LAND TECHNOLOGIES, INC.

Response to Comments

Project Name: Quality Auto Center
 Project File Number: PA22-005
 Review Completion: March 15, 2022

VEHICLE TRACKING SITE PLAN

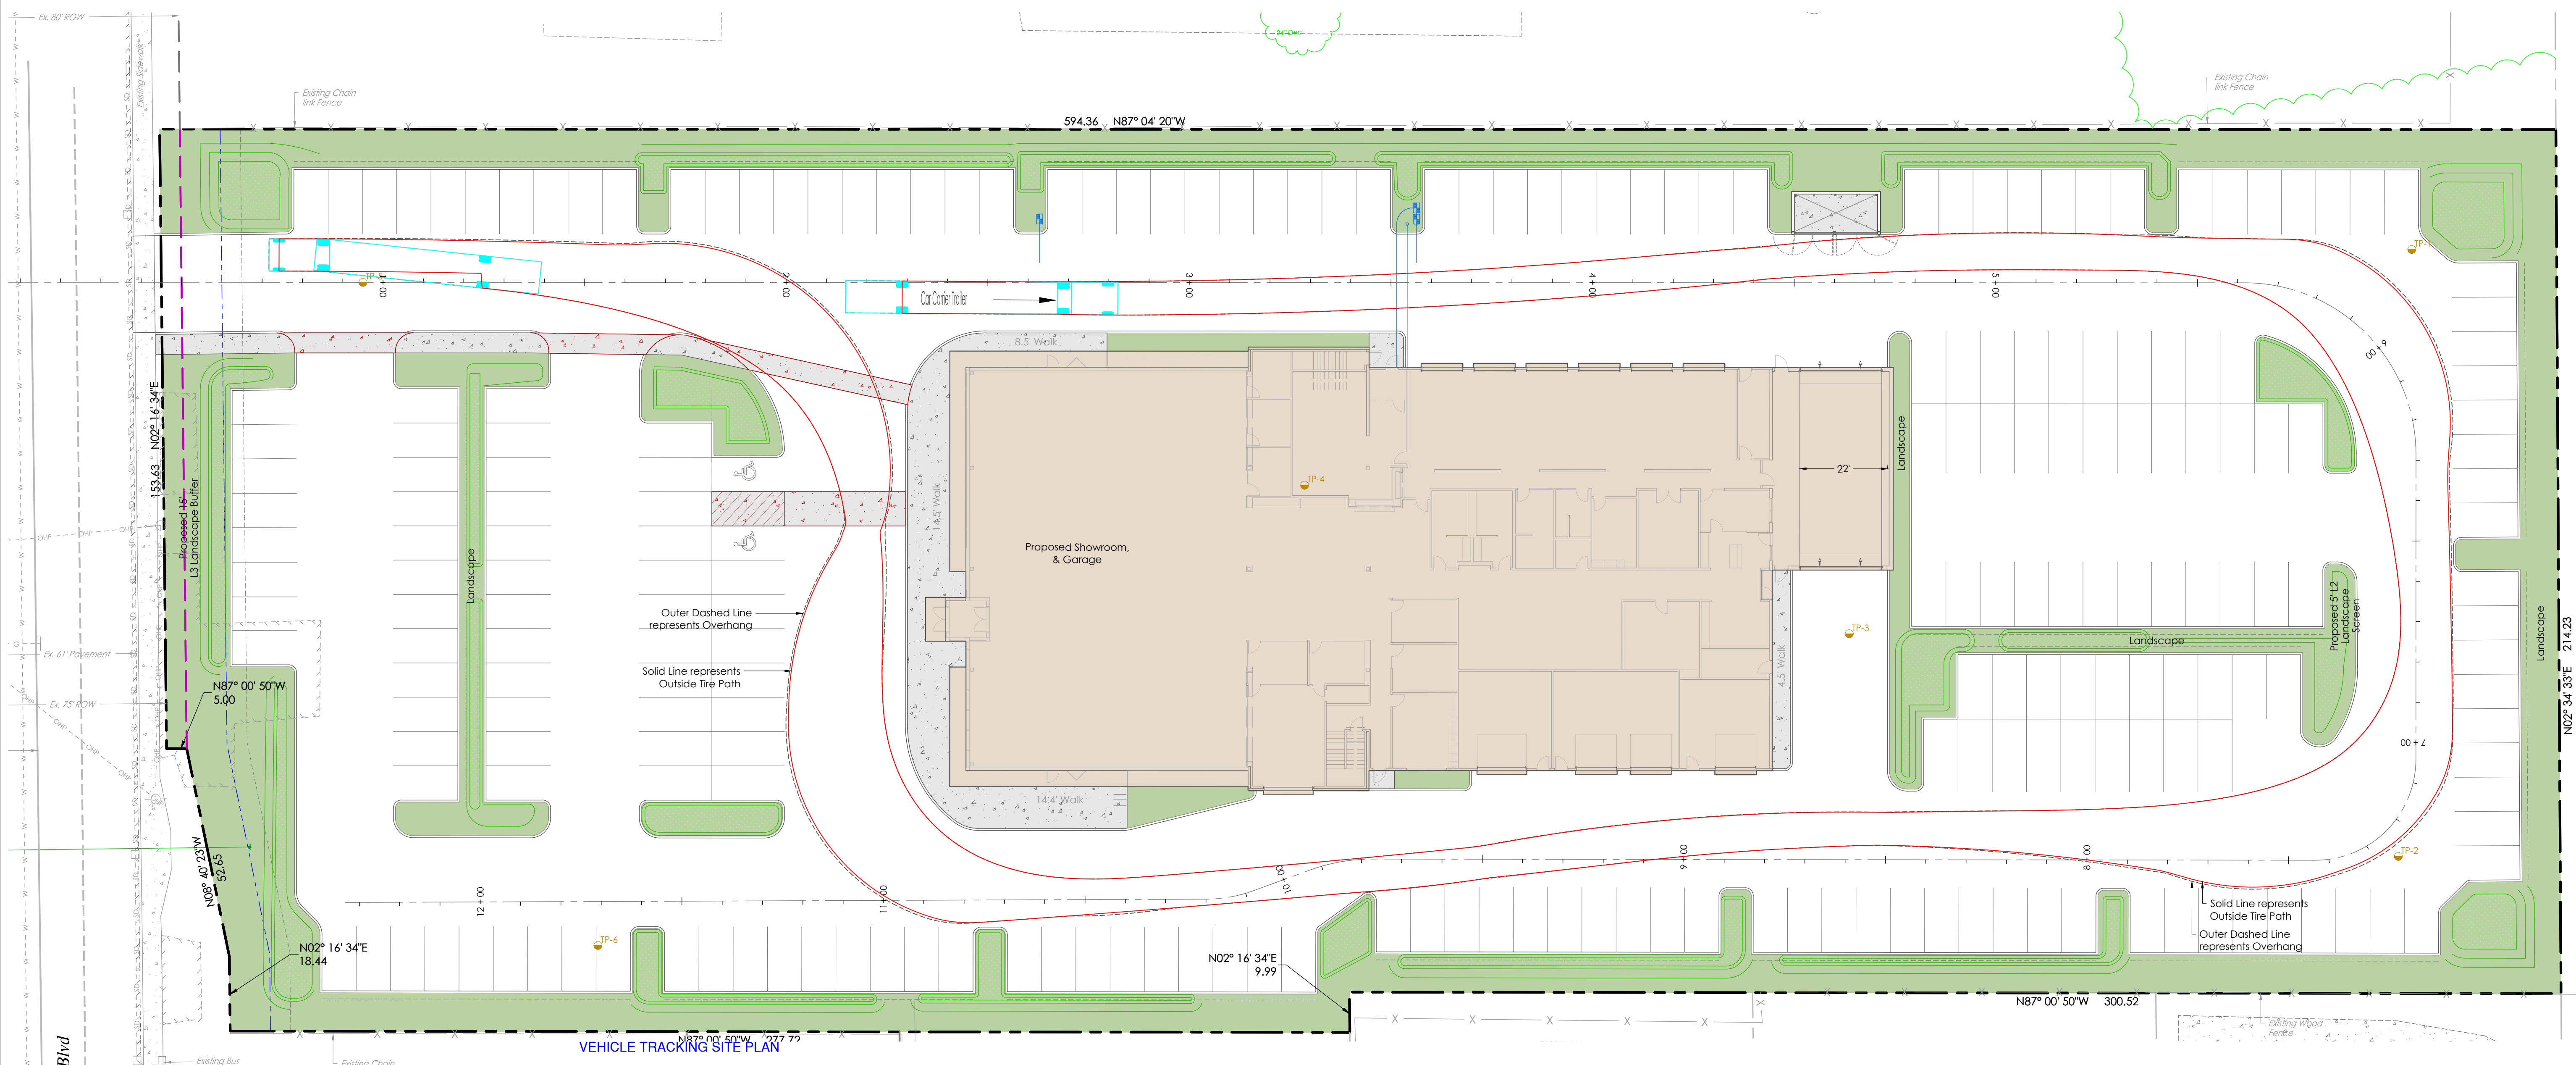
CITY COMMENTS	LAND TECH RESPONSE
<p>Recyclables standards outlined in MMC 22C.020.320. Utility meters, electrical conduit, and other service utility apparatus shall be located and/or designed to minimize their visibility to the public. If such elements are mounted in a location visible from the street, pedestrian pathway, common open space, or shared auto courtyards, they shall be screened with vegetation or by architectural features.</p>	
<p>4. Sheet A1.1: The autoturn analysis provided appears to show that car carrier truck and trailer would need to mount the landscape islands and travel into designated parking areas, or inventory lot to make the necessary movements for pick-up and delivery. The site plan will need to be amended to ensure the truck and trailer can navigate through the site without impacting landscape islands and designated parking areas, or the inventory lot.</p>	<p>The turning analysis works as shown on the Civil Plans which are showing the exact results of the turning analysis we provided.</p> <p>It may be the Architects site plan the wheel tracking lines are just a widget off graphically.</p>
